**WELWYN HATFIELD BOROUGH COUNCIL
EXECUTIVE DIRECTOR - PLANNING, PUBLIC PROTECTION AND GOVERNANCE**

Application No: 6/2019/1394/HOUSE
Location: Woodfield House Woodfield Lane Brookmans Park Hatfield AL9
 6JJ
Proposal: Erection of Conservatory
Officer: Mr William Myers

Recommendation: Refused

drawing
 Proposed Plans
 drawing number
 19989/PA/003
 revision

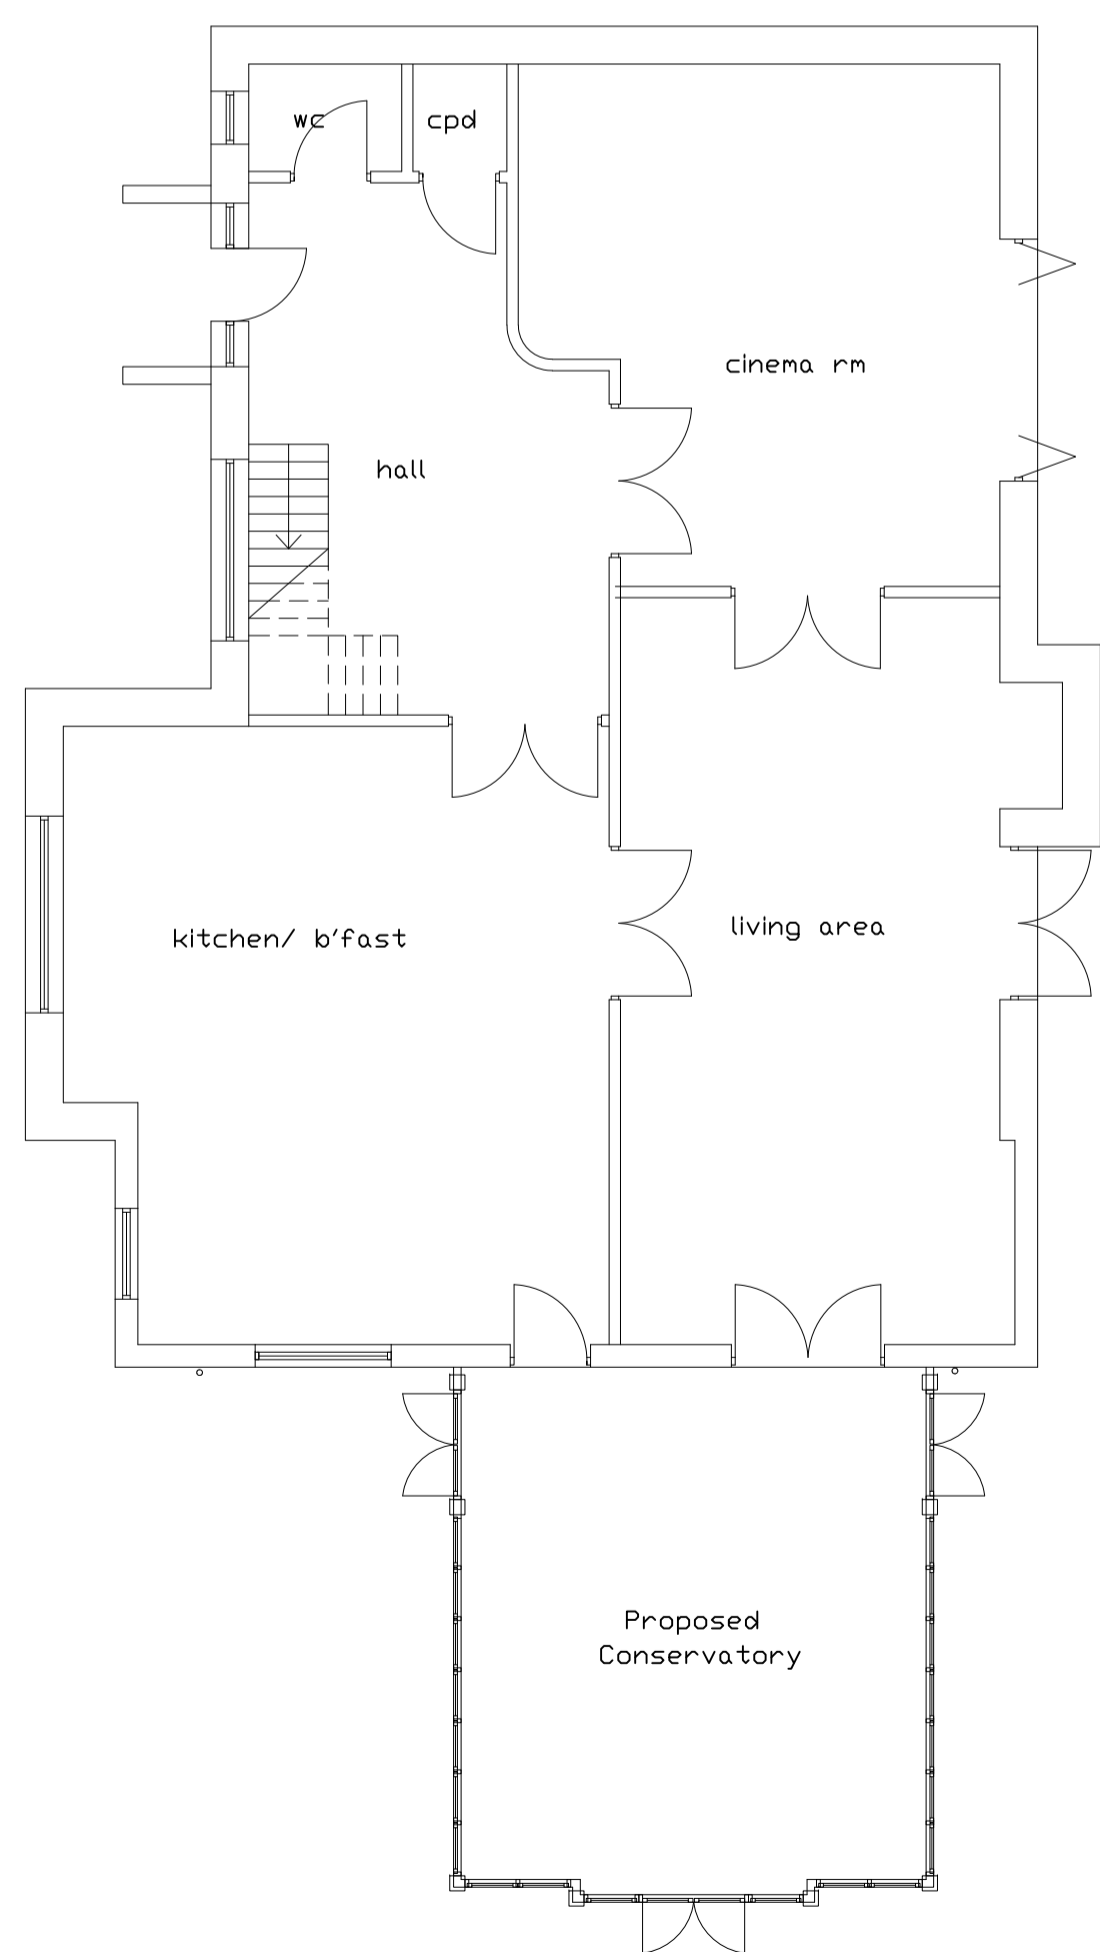
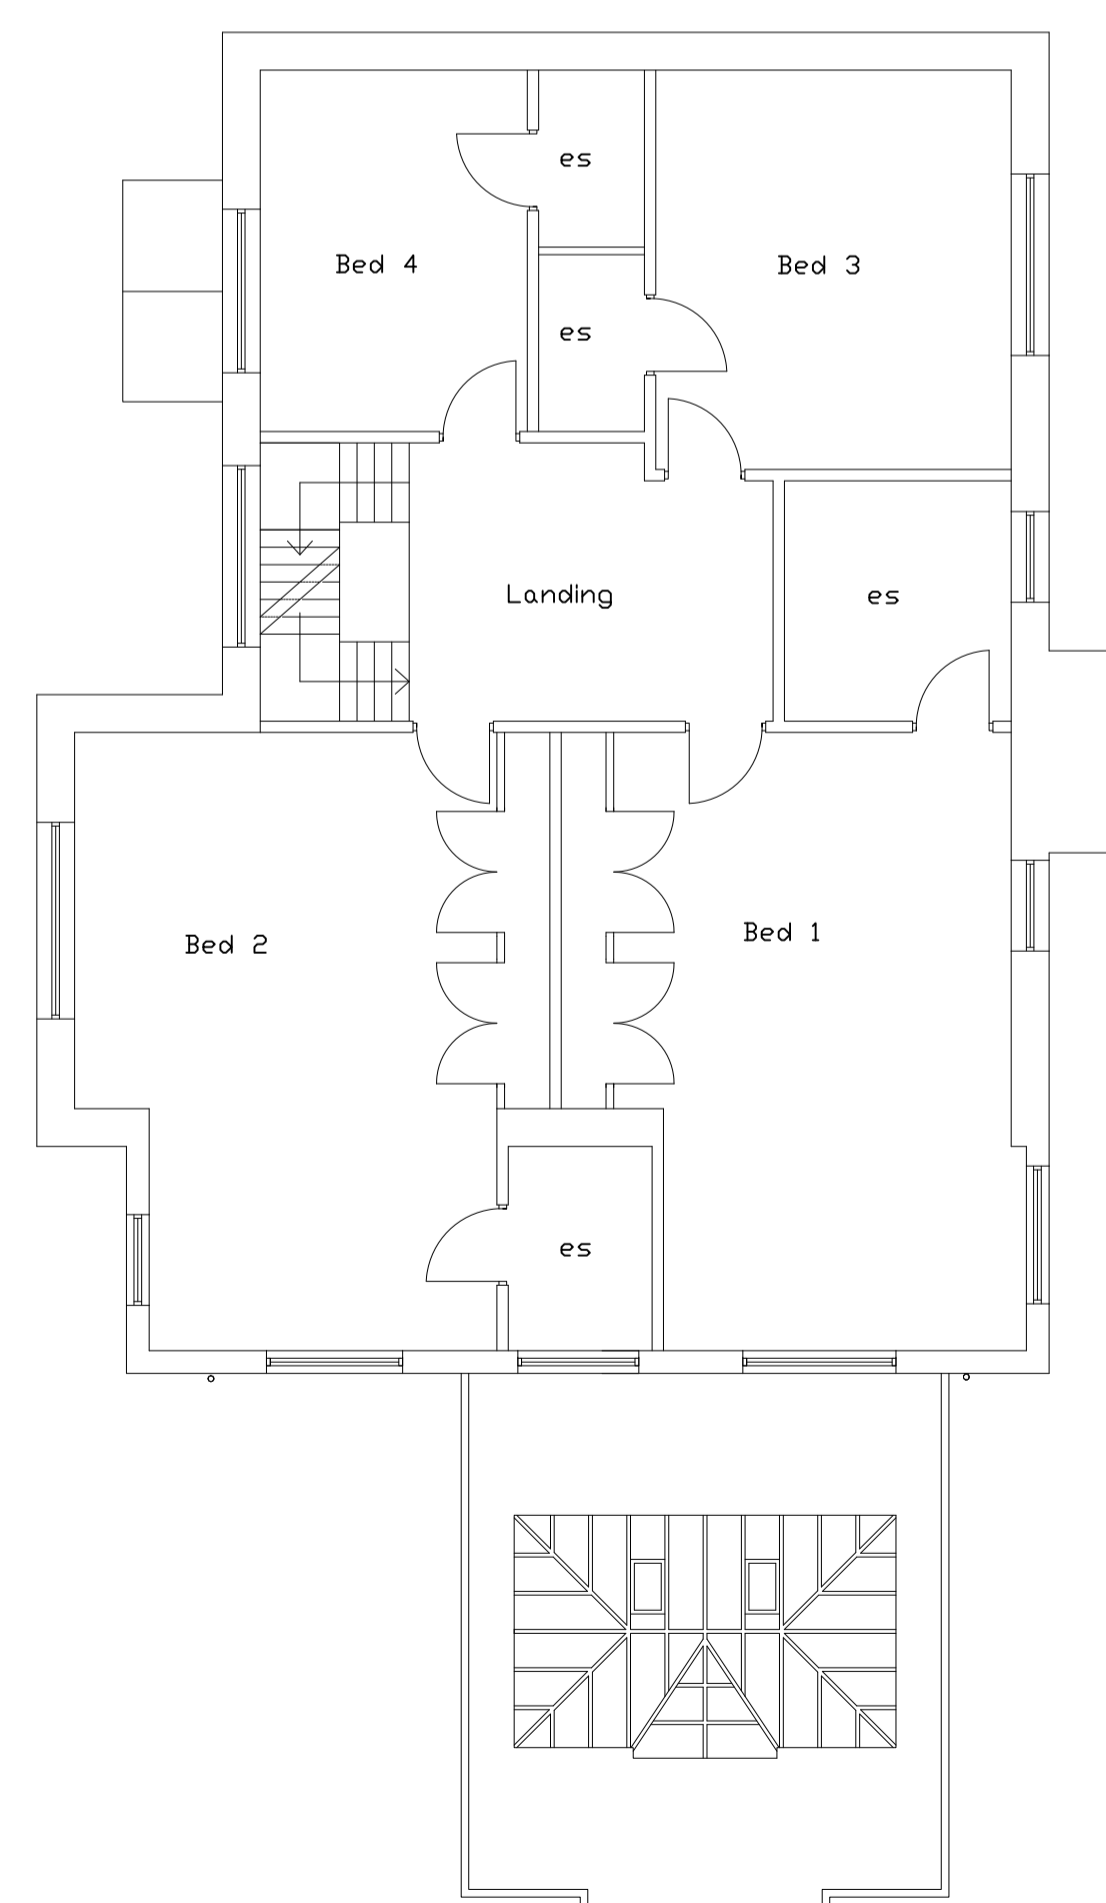
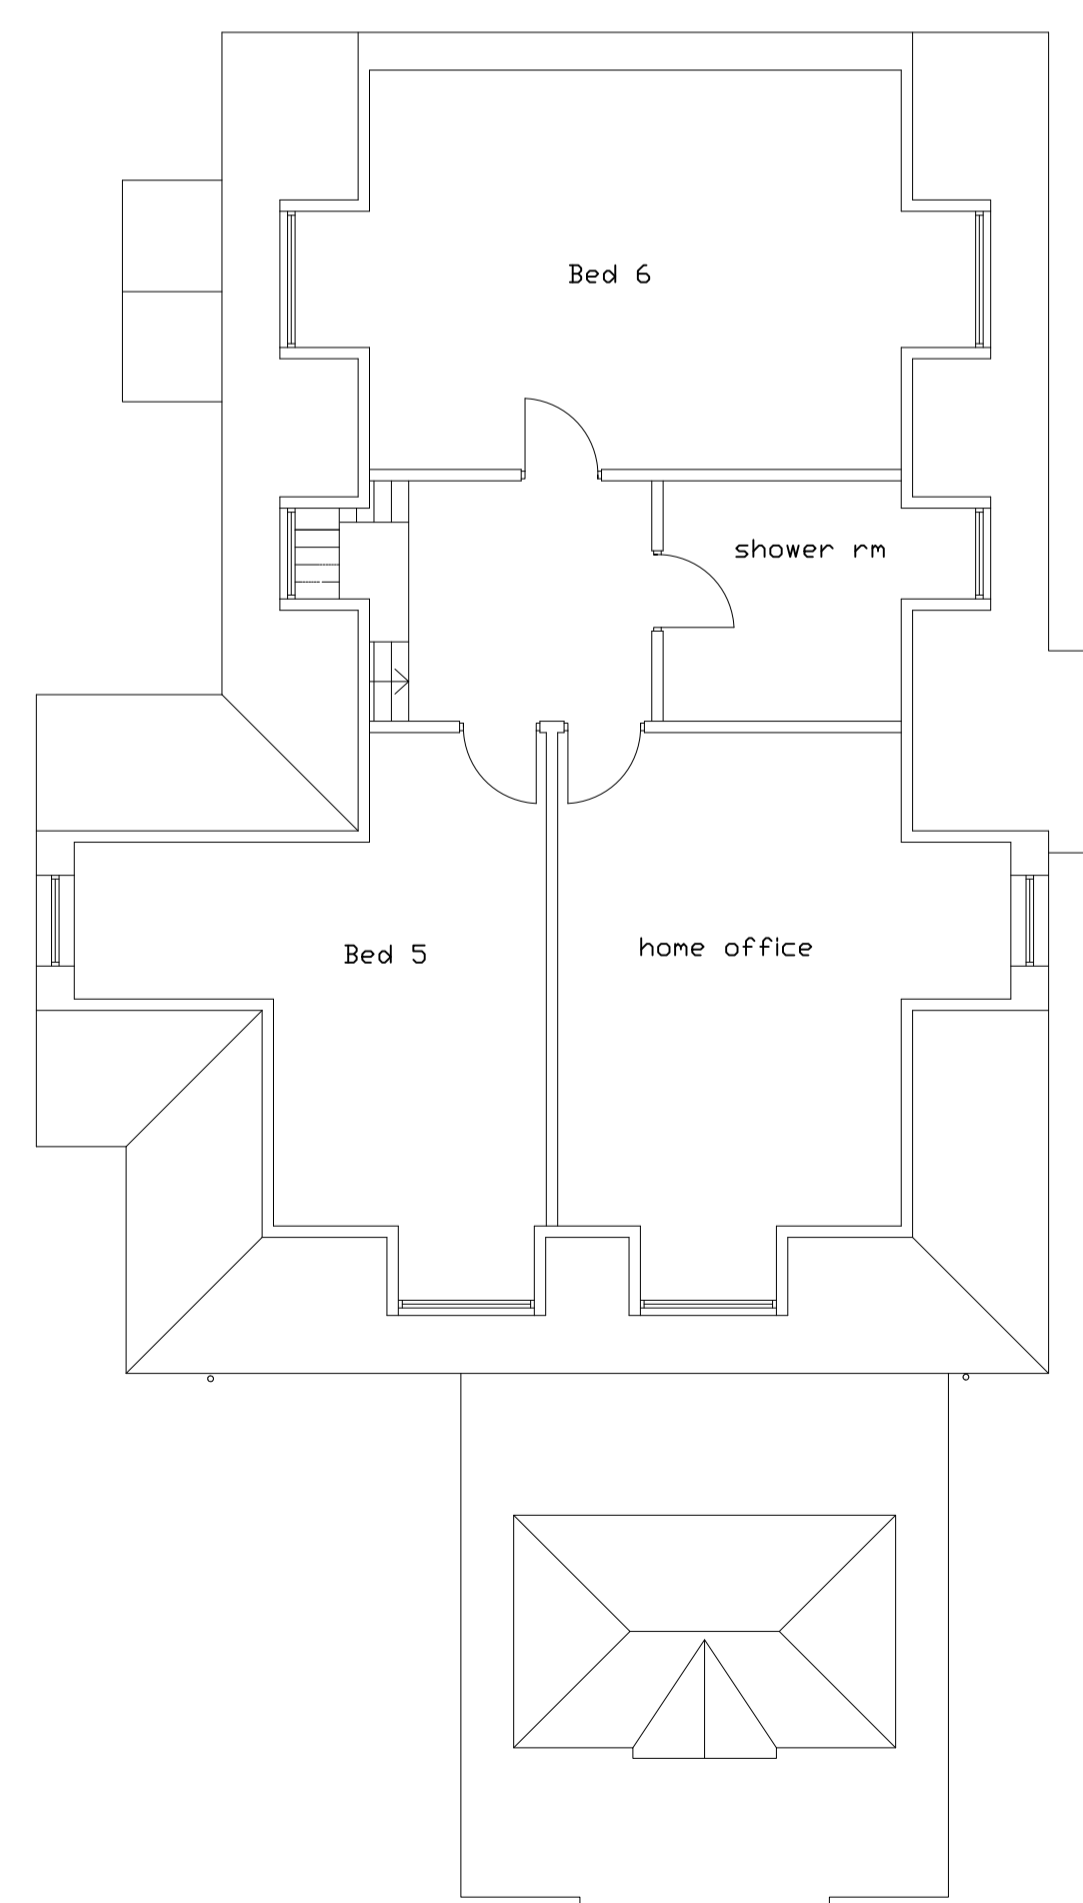
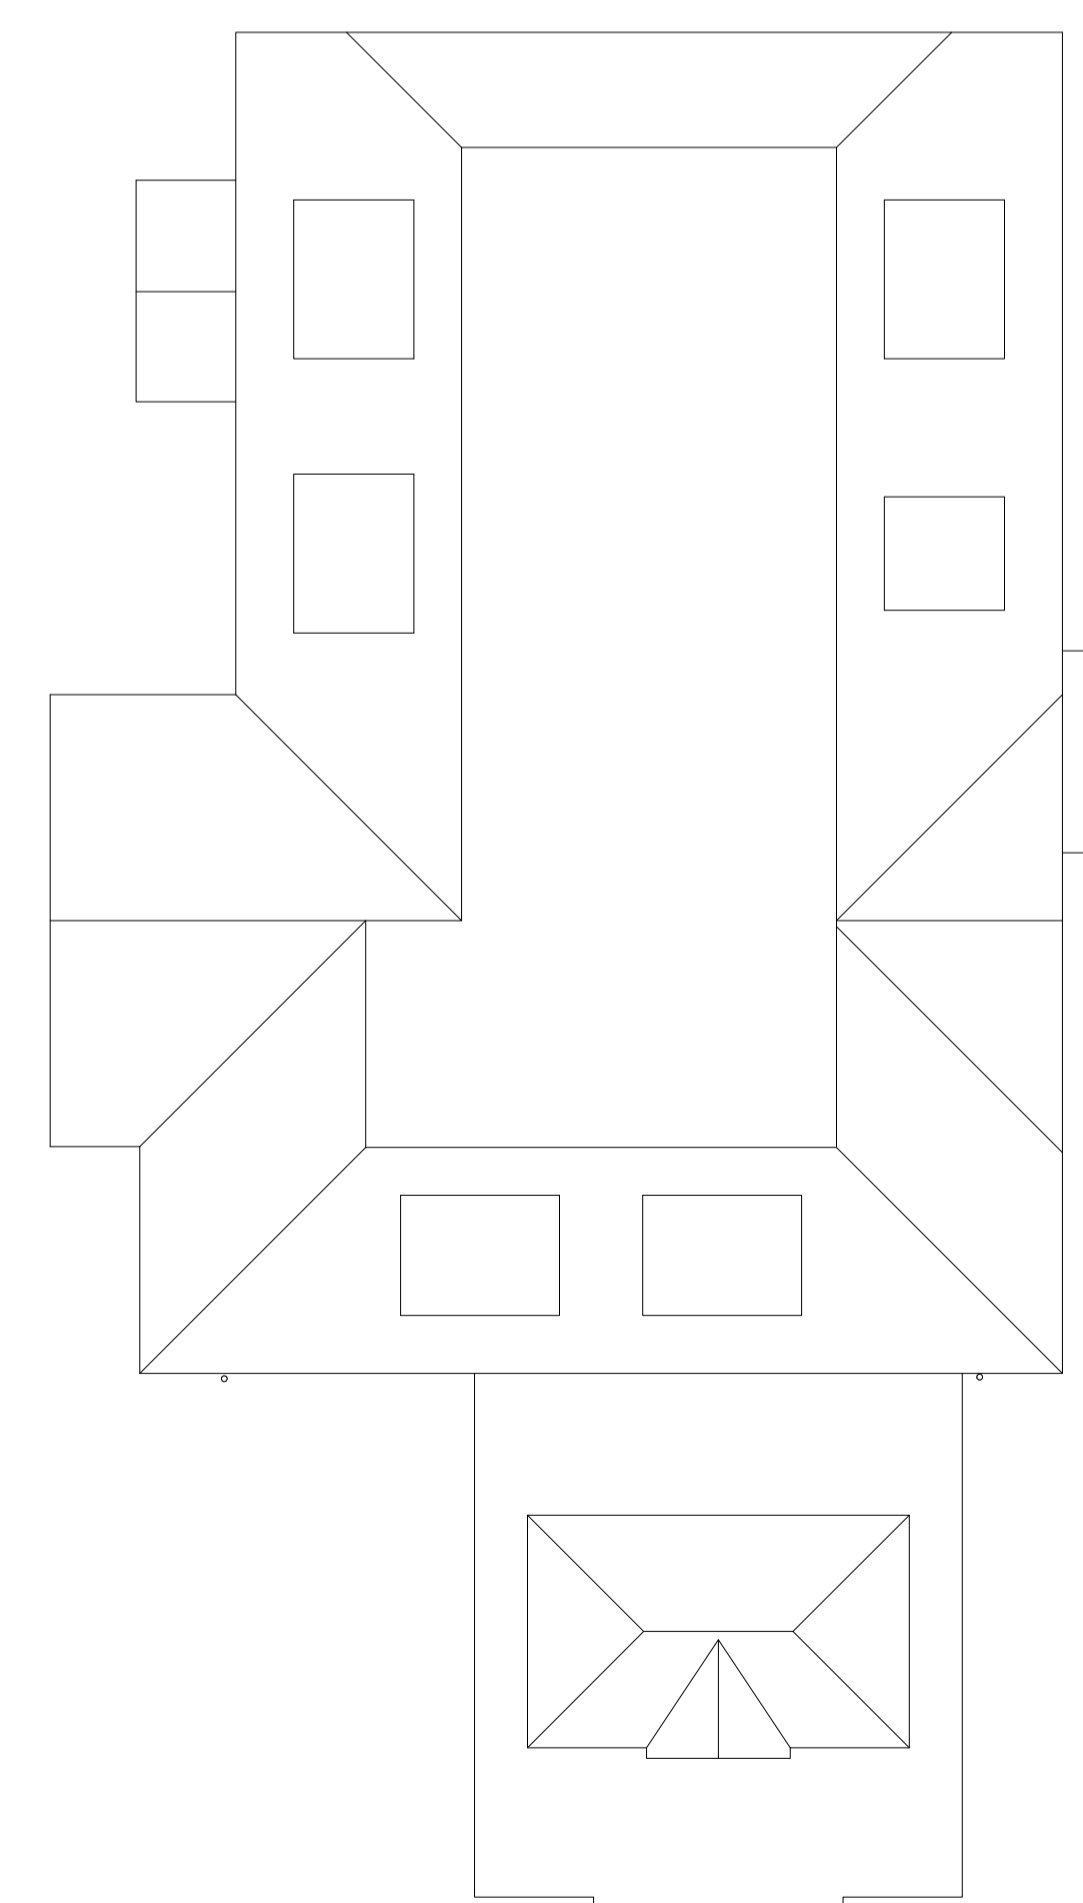
The proposed extension would result in the property being extended to its side with a single storey extension which would project approximately 6.9m beyond the existing side elevation. The proposed development would result in the creation of approximately 44m² of new floor space. This addition, taken cumulatively with the existing additions would represent approximately 86% increase above the size of the original dwellinghouse. On a purely mathematical calculation the extensions to the original building would be disproportionate. However, in addition to mathematical calculations the visual impact of the extensions has to be considered.

Further to the above discussions about the proposed increases, it is considered that such an addition to a dwelling, which has already been significantly extended, would have a harmful impact on the openness of Green Belt. It is judged that the proposed extension's size, design, bulk, as well as, its proposed location would fail to appropriately respect or relate to the character of the existing dwelling with the result that it would not appear to be a proportionate addition. The essential characteristics of Green Belts are their openness and their permanence and the loss of openness in the Green Belt resulting from the proposed extensions would conflict with this essential characteristic. Significant weight must be attached to this loss of openness.

<p>not result in disproportionate additions over and above the size of the original dwelling. Furthermore, the increased bulk and massing of the proposed development would result in a loss of openness and visual permeability of the Green Belt.</p>
<p>Design (form, size, scale, siting) and Character (appearance within the streetscene)</p>	<p>Local Plan Policies D1 and D2 aim to ensure a high quality of design and to ensure that development respects and relates to the character and context of the locality, maintaining and where possible enhancing the character of the existing area. These policies are expanded upon in the Council's Supplementary Design Guidance (SDG) which requires the impact of a development to be assessed giving regard to the bulk, scale and design of the proposal and how it harmonises with the existing building and area. These objectives are broadly consistent with the Council's Emerging Local Plan 2016 and the aims of the NPPF which considers that the creation of high quality buildings and places is fundamental to what the planning and development process should achieve.</p> <p>The proposed extension would represent a substantial addition to the dwelling at ground floor level as it would project approximately 6.9m from the existing side elevation of the dwelling and would have an approximate width of 6.4m. It is proposed that this addition would have the appearance of a conservatory or an orangery.</p> <p>As a consequence of the proposed extension position this substantial addition would be visible from the front of the property. Given that the proposed extension would appear as a conservatory, and it would be clearly visible from the front of the property, it is judged that it would appear as incongruous addition. The reason for this is that the extensions fenestration detailing and general design would not be in keeping with the existing fenestration detailing and design of the existing front elevation of the dwelling. Although it is considered that a conservatory with a similar appearance may be acceptable to the rear of the property it is judged that the proposed extension's size, design, bulk, as well as, its proposed location would fail to appropriately respect or relate to the character of the existing dwelling.</p> <p>Overall the proposed development would be excessive in size and would represent a poor standard of design with the result that it is contrary to the NPPF and Policies D1 and D2 of the District Plan which attach great importance to the design of the built environment and the SDG which seeks a design led approach to development.</p>

1. The proposal would represent inappropriate development within the Green Belt. In addition to this harm, there would also be harm to the openness of the Green Belt. Consequently the proposed development would conflict with Policy GBSP1 and RA3 of the saved Local Plan, Policy SADM34 of the Emerging Local Plan and relevant provisions of the National Planning Policy Framework 2019.
2. The proposed extensions would be of a poor quality of design and they would insufficiently reflect the design and character of the host dwelling. Accordingly, the proposal is contrary to Policies D1 and D2 of the Welwyn Hatfield District Plan 2005, the Supplementary Design Guidance 2005 (Statement of Council Policy 2005) and National Planning Policy Framework 2019.
